WEST SUSSEX COUNTY COUNCIL CONSULTATION

TO:	Arun District Council FAO: Mrs. A. Gardner
FROM:	WSCC - Highway Authority: Tim Townsend
DATE:	15th October 2019
LOCATION:	Land At Toddington Farm North And West Of 1 To 3 Toddington Toddington Lane Littlehampton BN17 7PN
SUBJECT:	LU/295/19/DOC Approval of details reserved by condition imposed under ref APP/C3810/W/18/3197149 (LU/162/17/PL) relating to Condition Nos 9 - landscaping, 10 - Construction Management Plan, 13 - vehicular visibility splays, 14 - pedestrian visibility splays, 16 - cycle parking and 18 - street lighting.
DATE OF SITE VISIT:	n/a
RECOMMENDATION:	Advice/More Information/Modification
S106 CONTRIBUTION TOTAL:	n/a for purposes of this DOC application

This is the WSCC County Highways (CHA) response to the above planning application for approval of details reserved by condition imposed under ref APP/C3810/W/18/3197149 (LU/162/17/PL) relating to Condition No's 9 - landscaping scheme, 10 - Construction Management Plan, 13 - visibility splays, 14 - pedestrian visibility plays, 16 - cycle parking and 18 - street lighting.

Construction Management Plan Layout

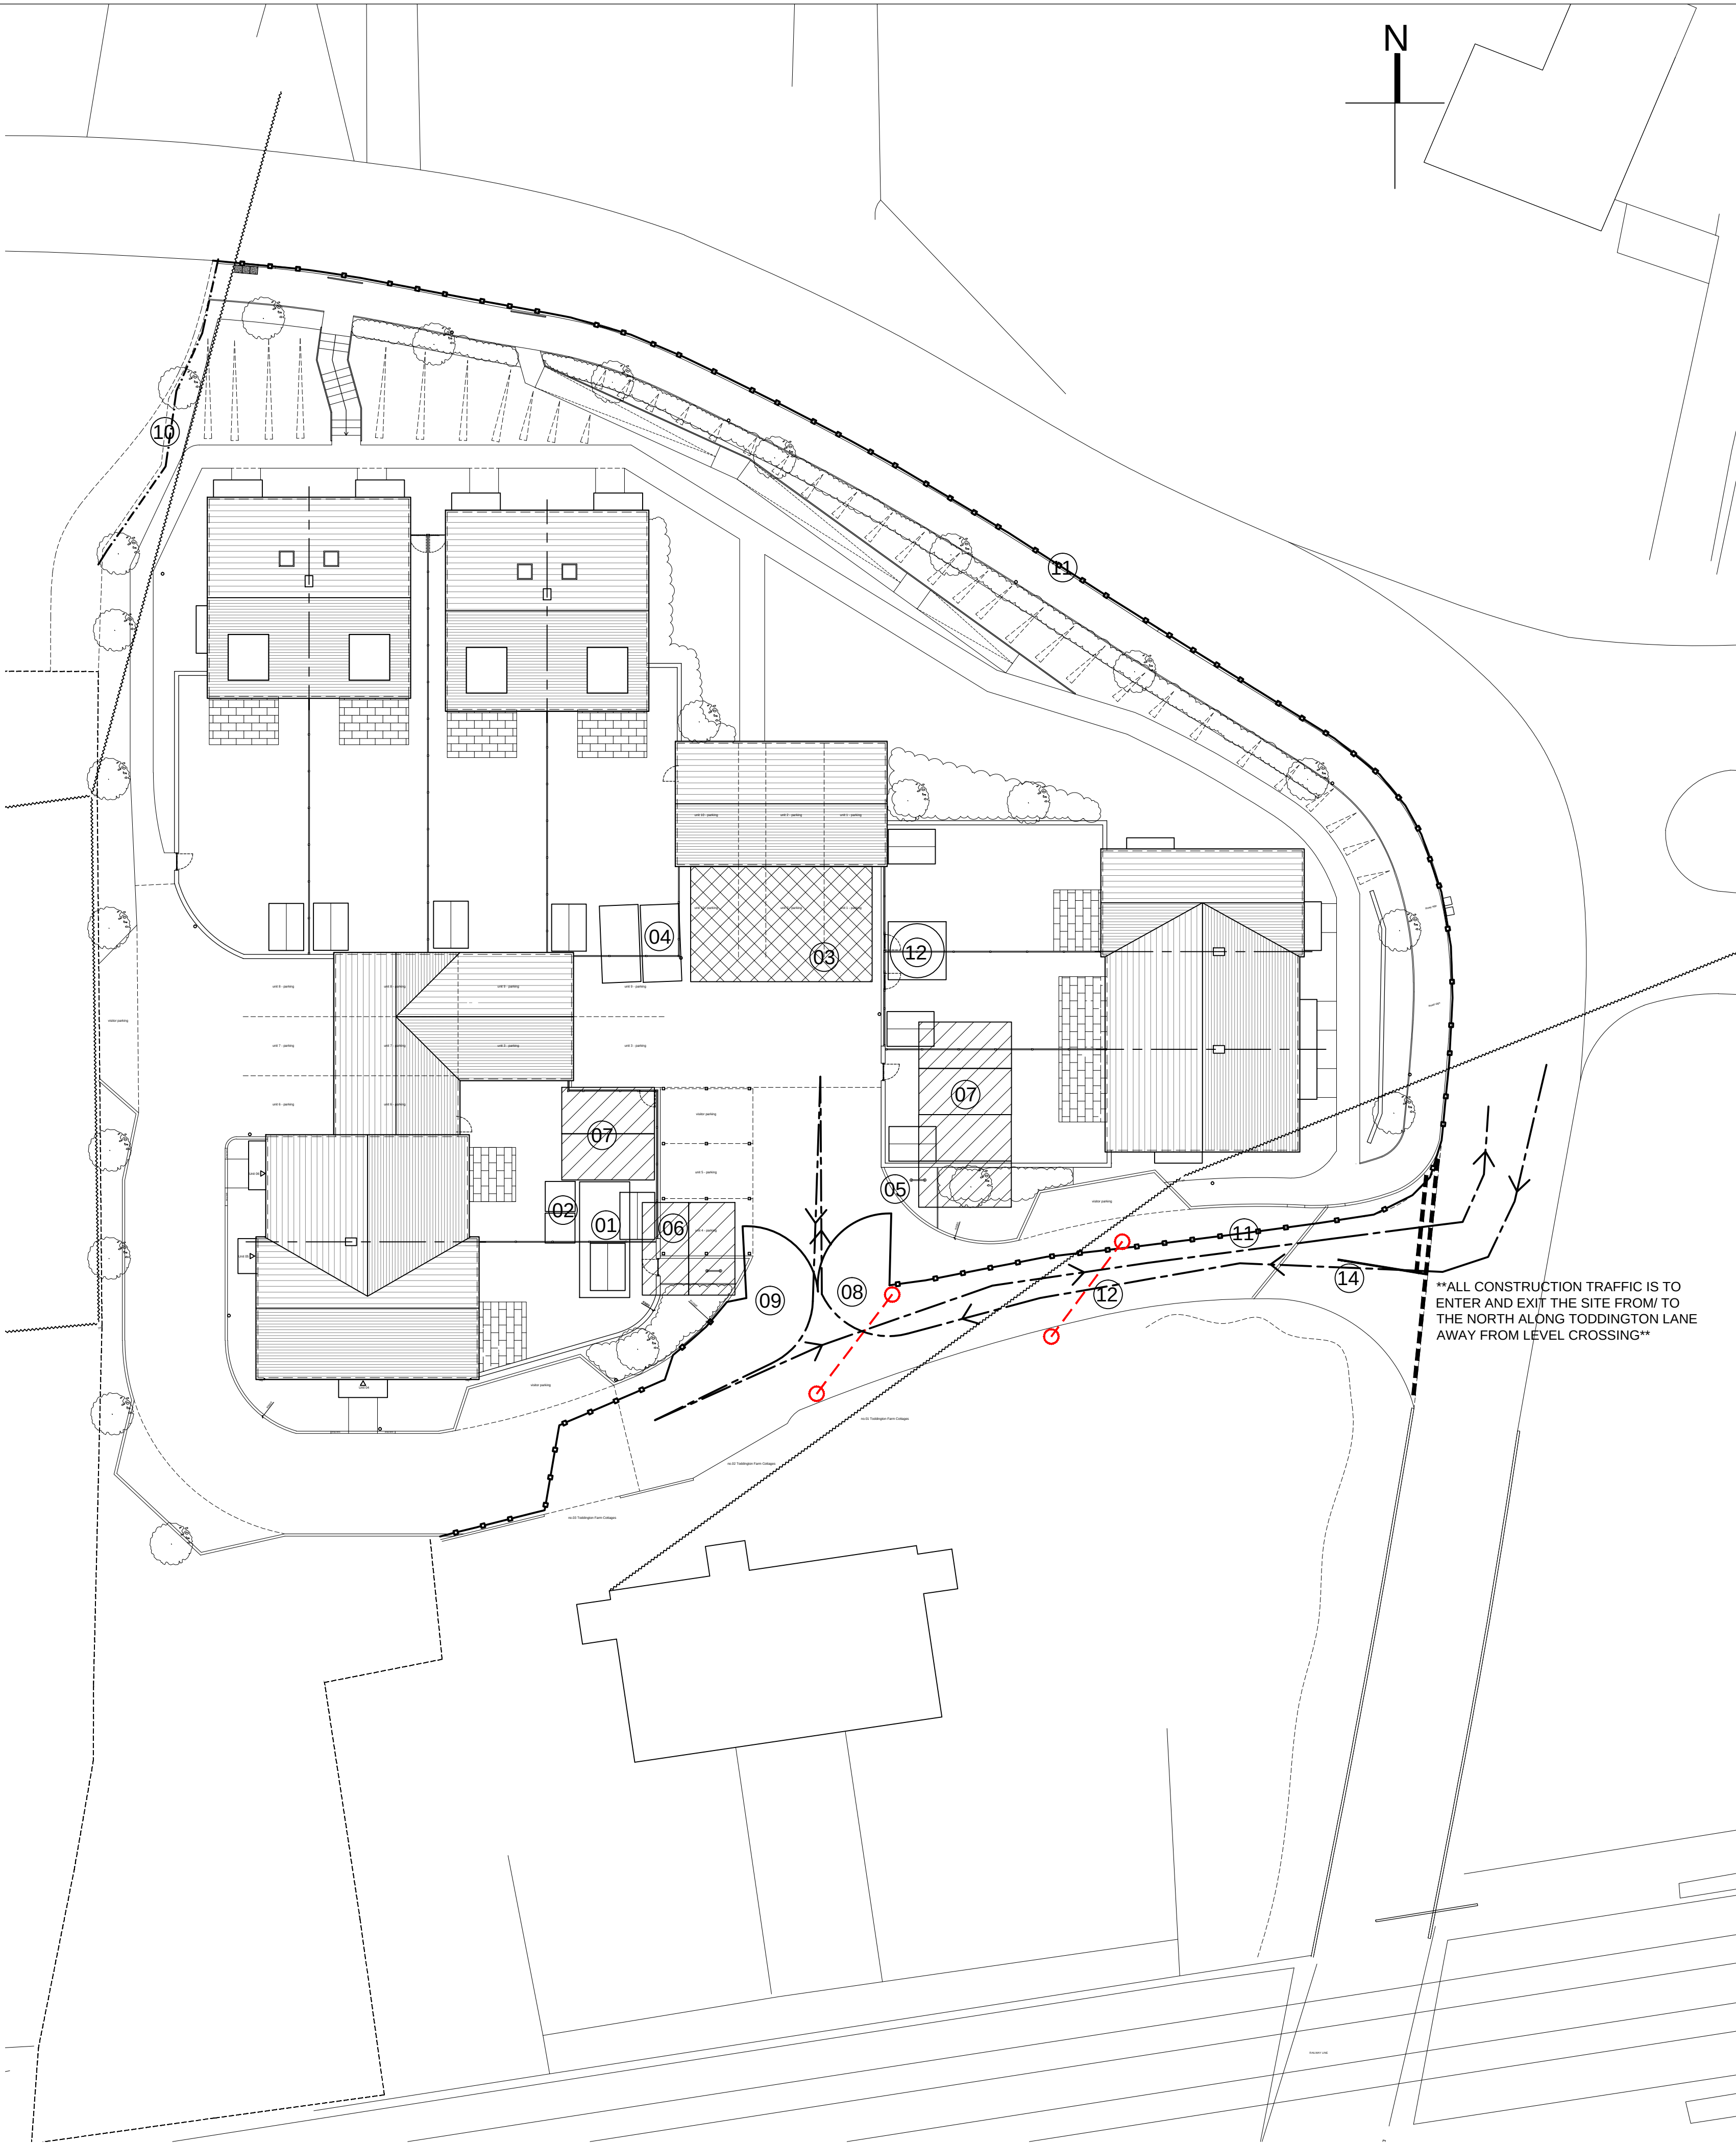
2. *Condition 10 (Construction Management Plan)* – The following items should be added to the CMP:
 - Construction routing plan to demonstrate no access to-or-from the south. All deliveries to enter from and leave to the north to avoid Toddington Lane and the adjacent railway crossing. **Now shown/confirmed.**
 - A plan showing parking for contractors and visitors on the site clear of the public highway. **Now shown.**
 - A plan showing areas for materials storage on the site and clear of the public highway. **Now shown.**

Proposed Garden Shed - 1:50 @ A1
(secure cycle storage)

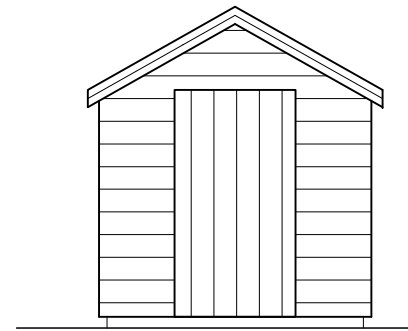
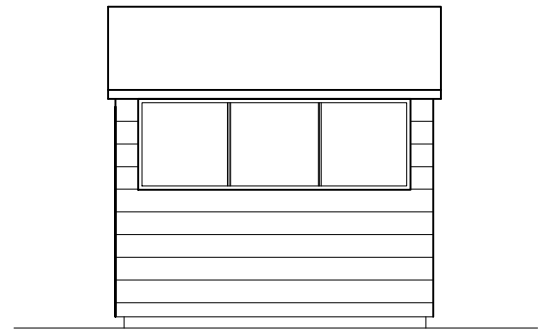
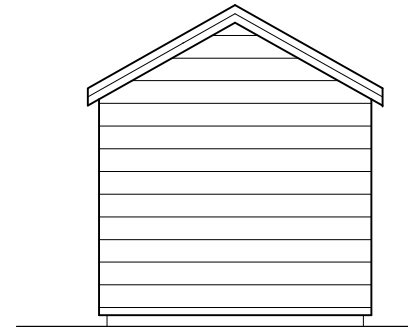
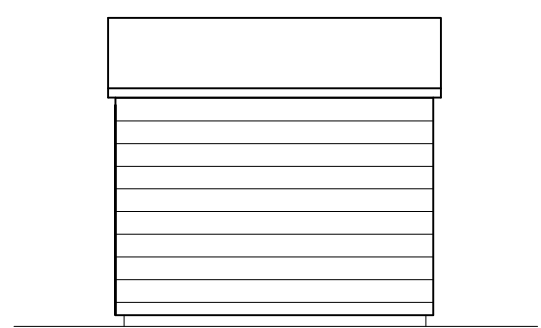
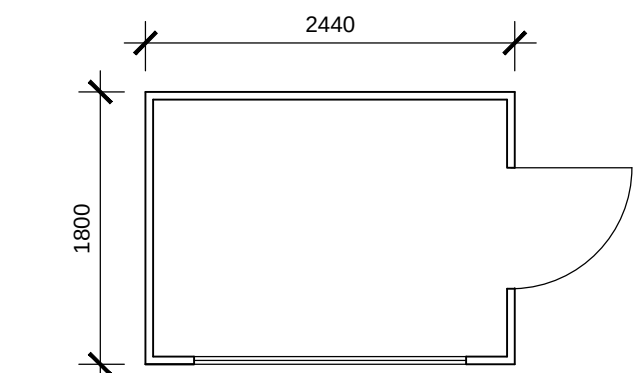
5. *Condition 16 (cycle parking)* – Applicant needs to demonstrate cycle parking for plots 4 and 5. Currently, only one shed is shown.
6. *Condition 18 (street lighting)* – Street lighting on land forming part of the public highway will be considered through the S38/278 Agreement process required to construct on land forming public highway – including access works.

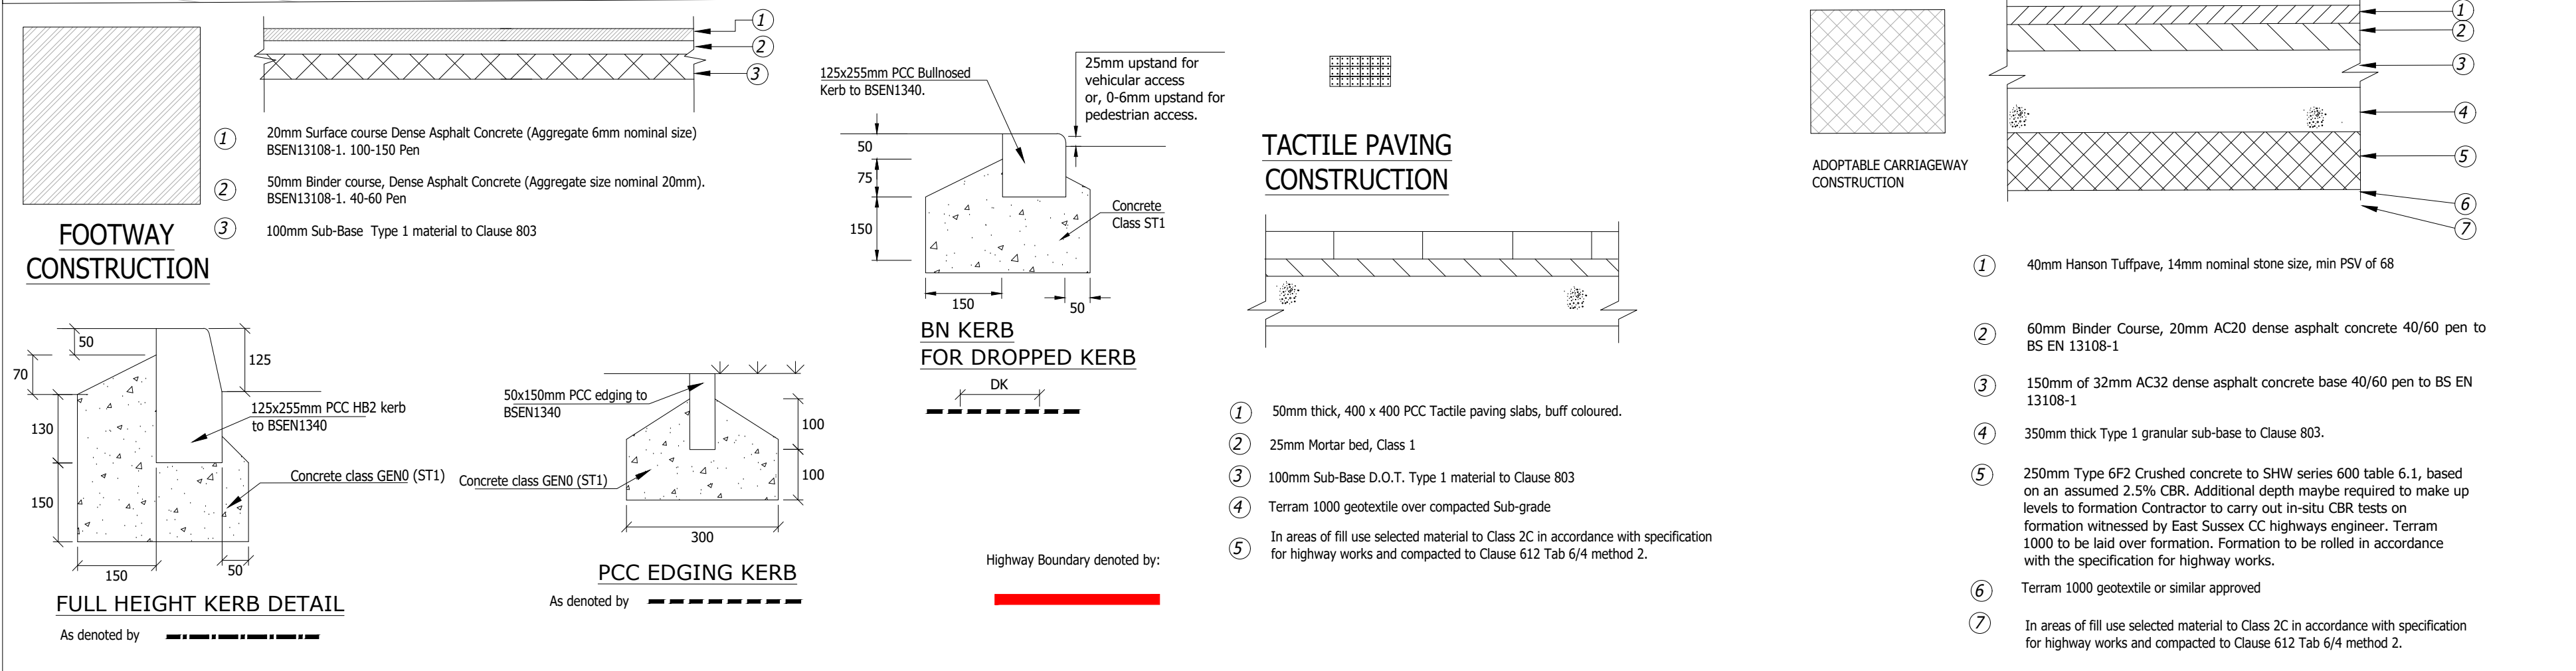
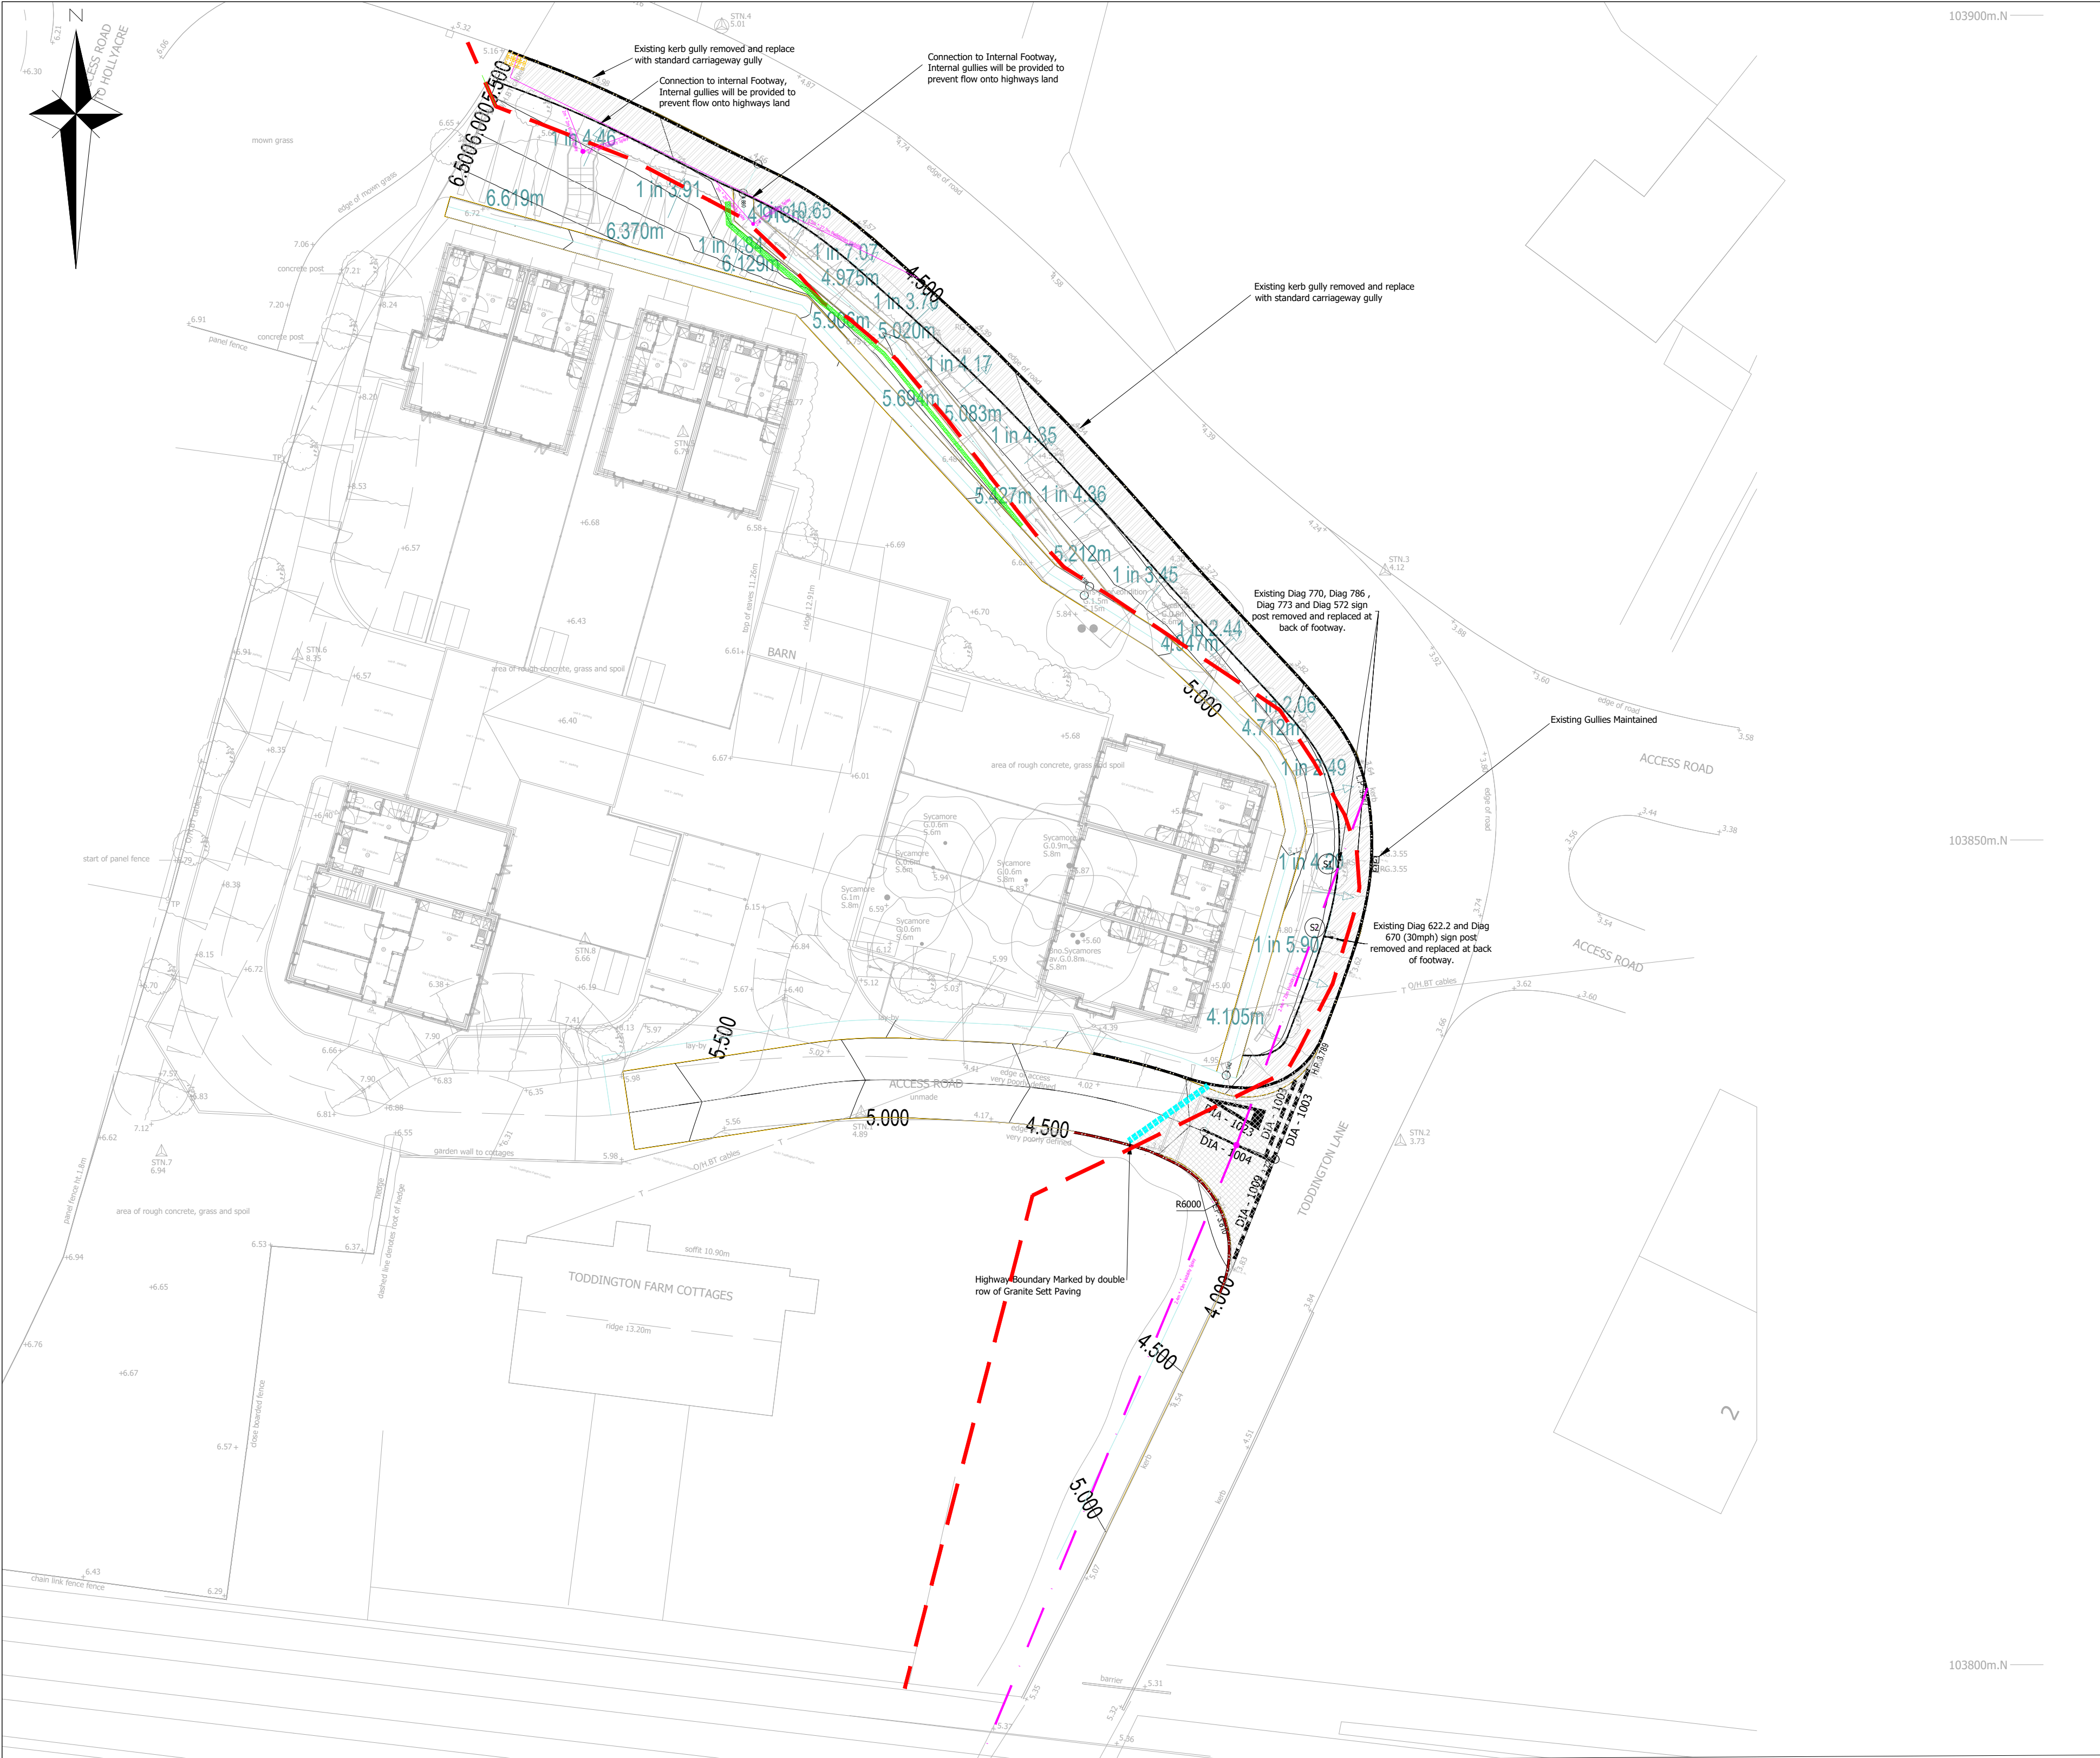
3. *Condition 13 (visibility splays)* – The visibility splays shown in both directions taken from a 2.4m 'x' (centreline) distance appear to concur with that considered and approved as part of the recent Planning Appeal decision for the development site. Splays are shown at 43m in the leading traffic direction (so looking south from the access) and 23m in trailing direction (looking north). Please note that the structure shown in front of plots 1-3 might need to be assessed further at the detailed design/S278 stage.

4. *Condition 14 (pedestrian visibility splays)* – The pedestrian intervisibility splays to the back of the footway where they emerge now appear to be shown correctly. However, the splay (suitable for peds/motorists) needs to be extended which will take it across part of the site frontage. This will be where pedestrians will be entering the carriageway to either walk along the kerb edge or attempt to cross to the north side of the road given that the footway terminates at this point. The visibility splay for those crossing at the western-end of the proposed footway should be taken from a 2.0m 'x' distance and provide 66m in both directions. This is based on a 2.5mph walking speed, 30mph speed limit and 5.5m wide road.
